City of Albuquerque Stormwater Construction Site Inspection Report

ESC File No.	C18E075	Project Name:	Stillbrook @ Sevano Place Subdivision		
NPDES Id. No.	NMR1003UE	Location:	6300 Alameda Blvd. NE		
10/25/2021	Owner	Contractor			
Operator	Stillbrooke Homes	Stillbrooke Homes			
Contact name & title	Chris Kelsey	Chris Kelsey			
e-mail	ckelsey@stillbrooke.com	ckelsey@stillbrooke.com			
Contact Phone #	505-858-1800	505-858-1800			
COA Inspector	Doug Hughes	Start/End Time:	4pm		
Construction Phase:	Vertical				
Type of Inspection:		Storm Event	Past Storm Event >0.25"	311/Complaint	Follow Up
Weather at time of inspection?		clear	Temperature: ~		73
Estimated date of last storm 0.25" or greater		9/30/2021

CONCRETE WASHOUT

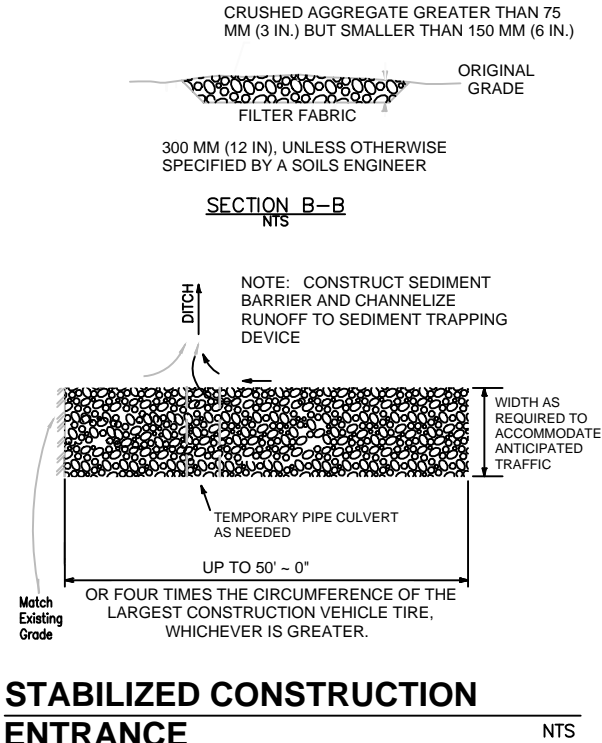
Item Number	Deficiency/ Corrective Action				
1	Concrete/stucco Washout on the ground and no containers.				
2	The up-to-date SWPPP was not available onsite				
3	NPDES Posting doesn't include StillBrook ID # NMR1003UE.
